Ref: EP/52/18/PL

Re: Local Planning Authority Reference EP/52/18/PL

For: Demolition of existing dwelling & the erection of 7No. residential dwellings, with associated parking, amended access location from Lime Tree Close & landscaping.

At: Scorton 9 Lime Tree Close East Preston BN16 1JA.

Proposed Elevations & Floor
Plans, The Street Cottages

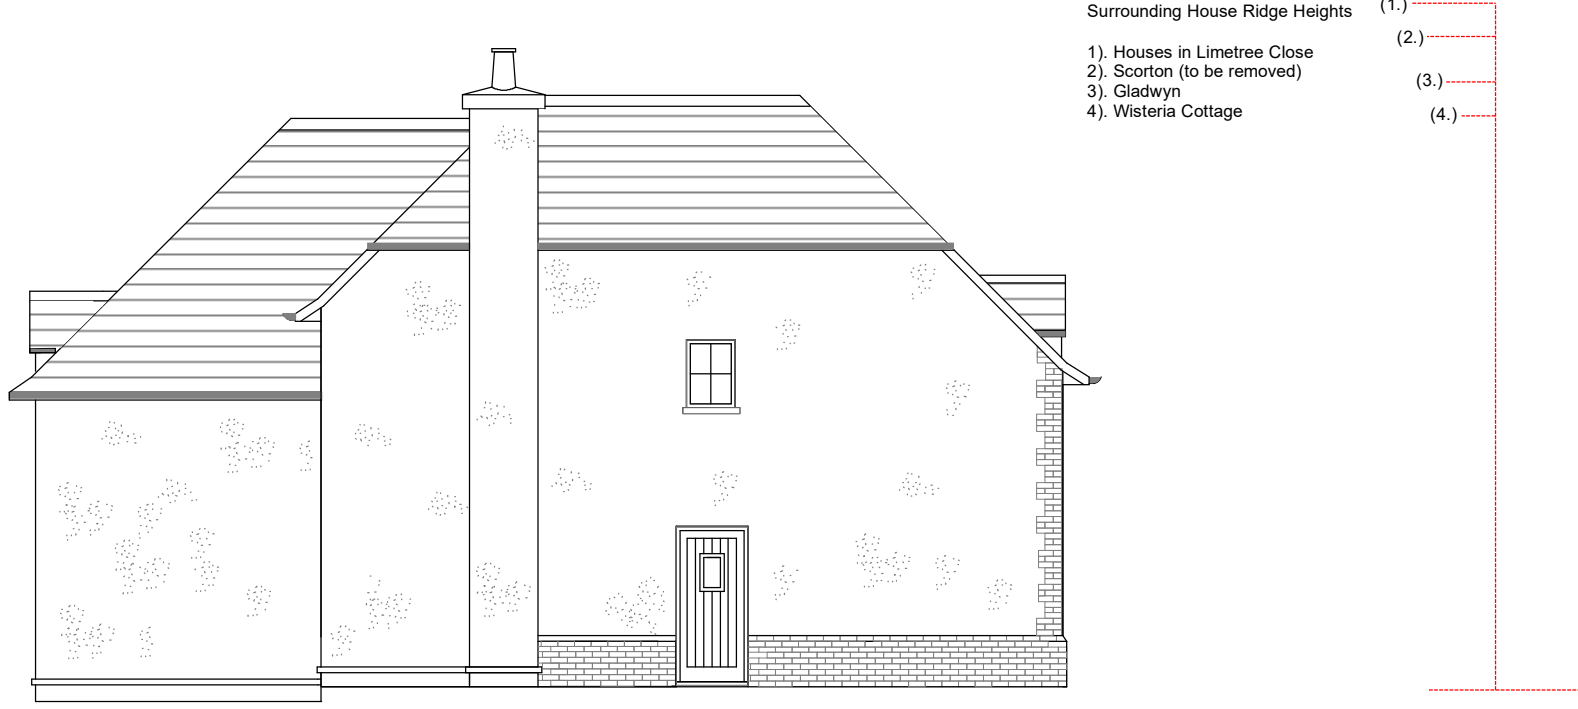
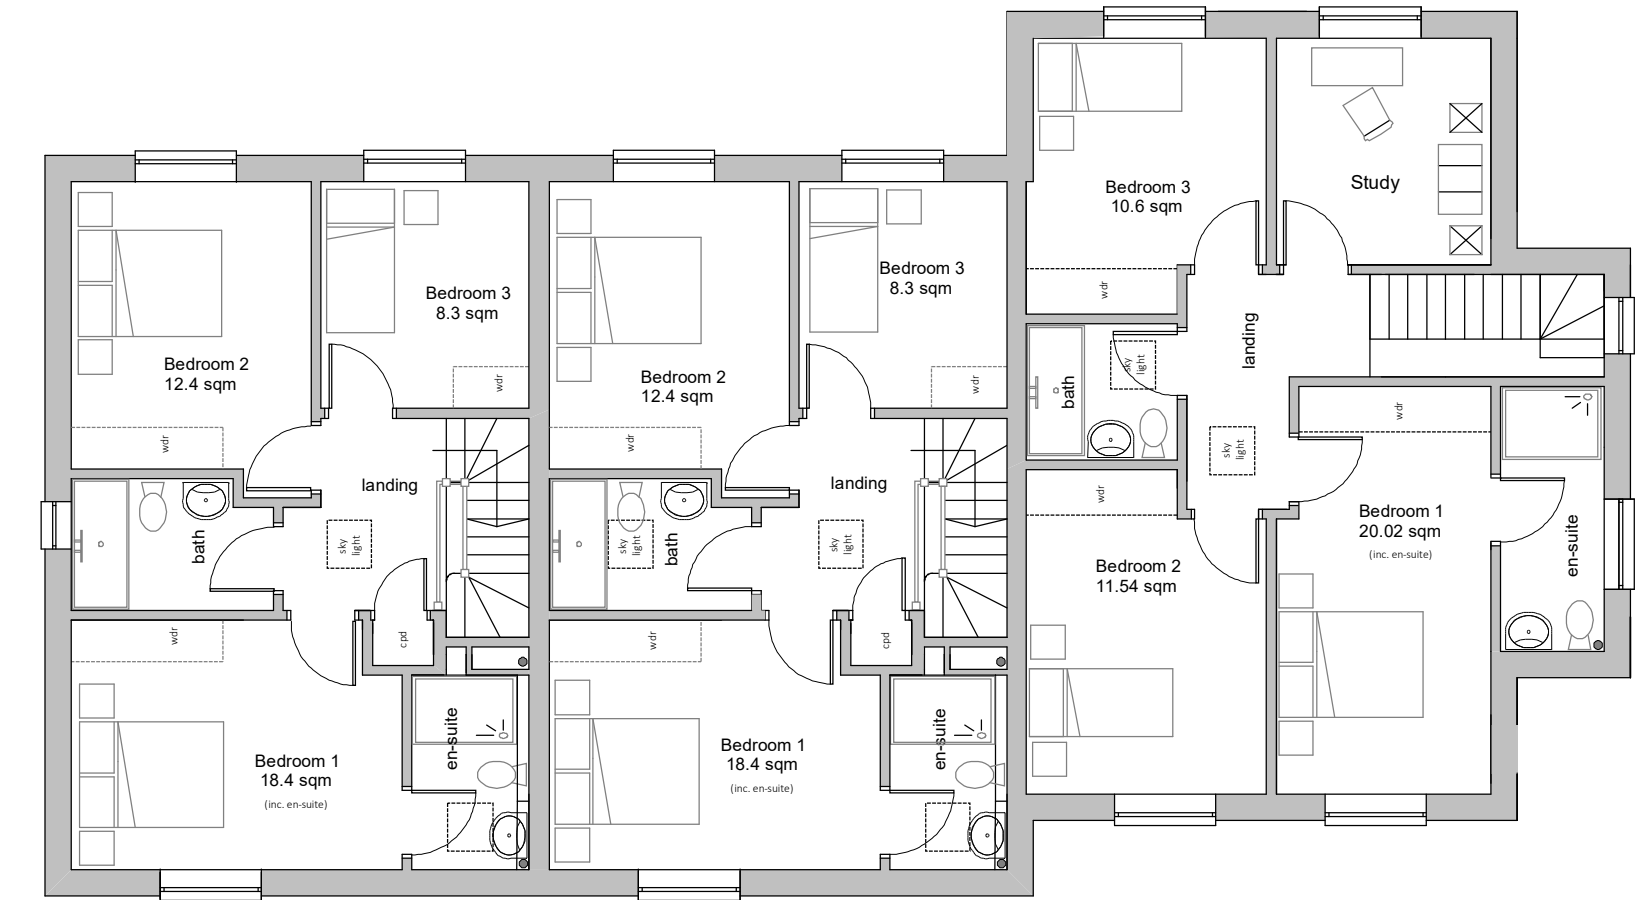
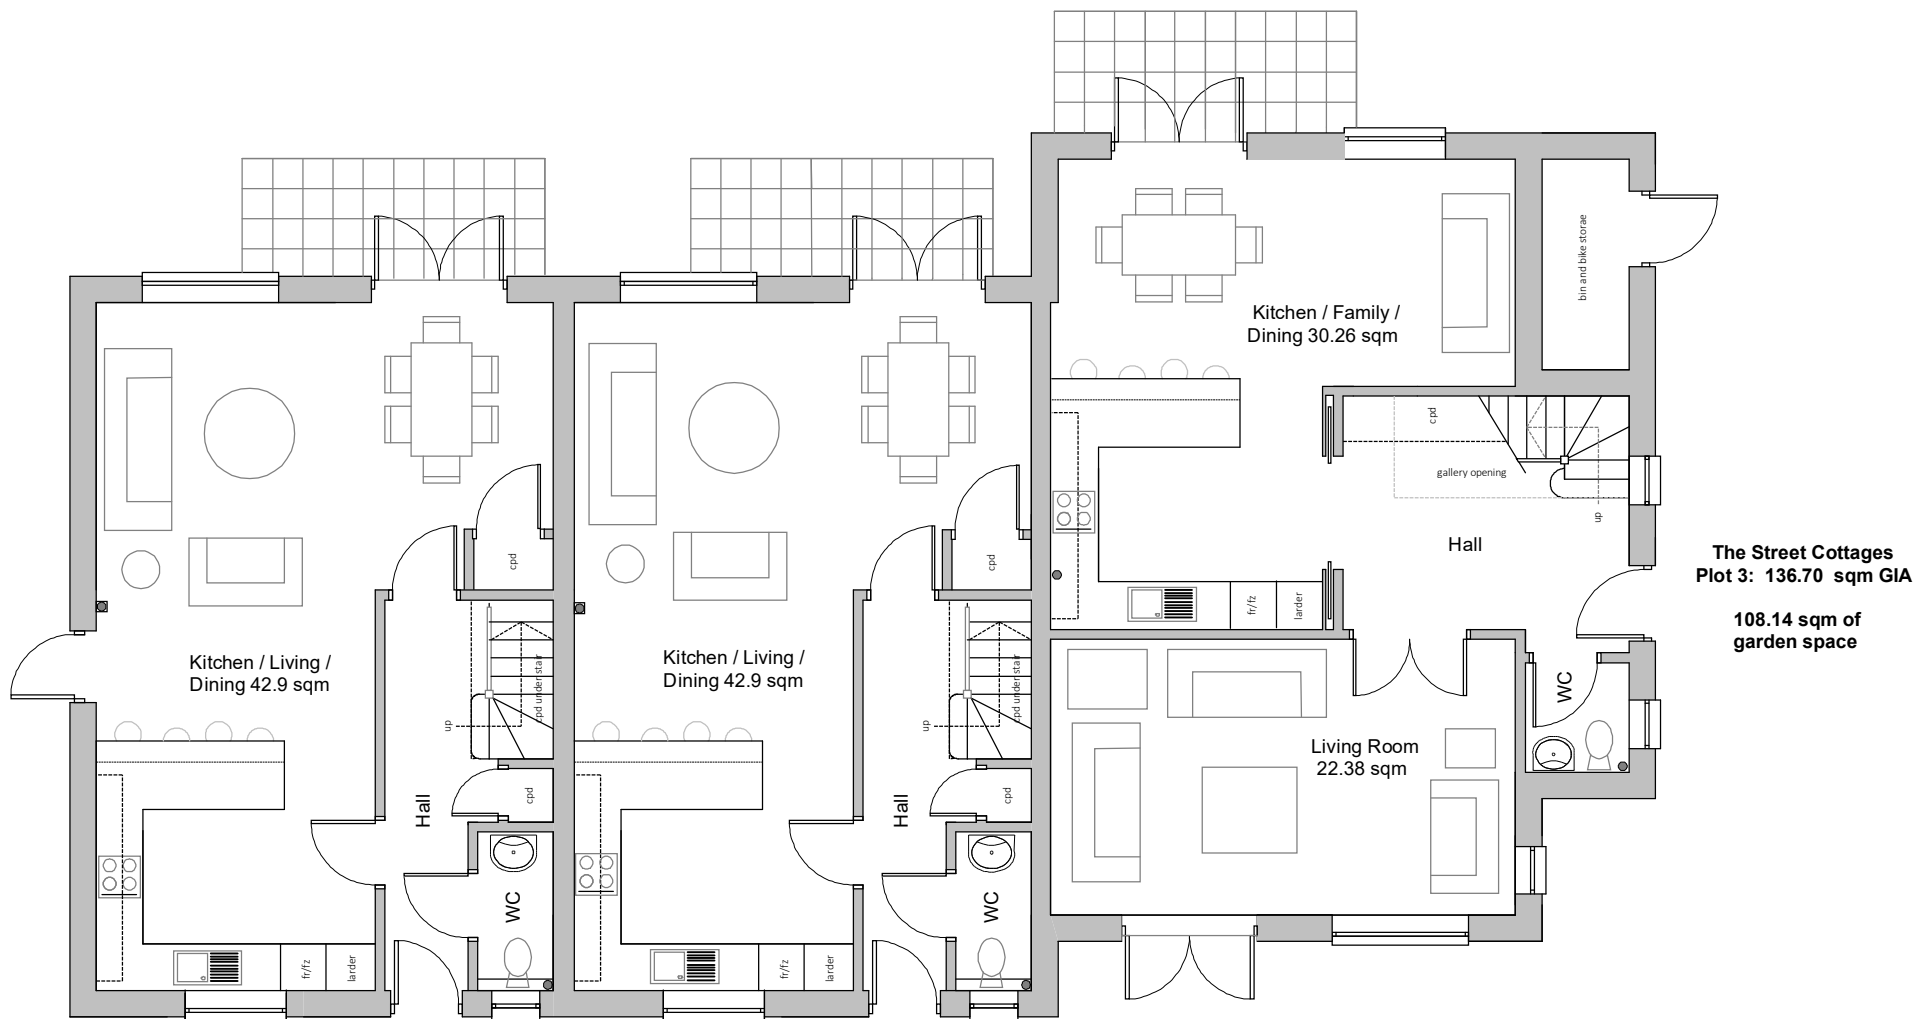
The three terraced cottages (Street Cottages) located within the currently undeveloped western end of the site would have the most impact upon our property as they would be a completely new building on previously undeveloped land and in direct view from us.

In addition to the overall impacts on the character of the village the proposal, particularly The Street Cottages, would form a very dominant structure directly opposite our property. Not only would this detract from the attractiveness and historical significance of the listed building but also due its orientation directly facing Wisteria Cottage be very overbearing and intrusive. The upper-storey windows of the cottages would overlook our bedroom window at the southern end and our garden at the northern end. Overall, the design and orientation of the Street Cottages would compromise our privacy.
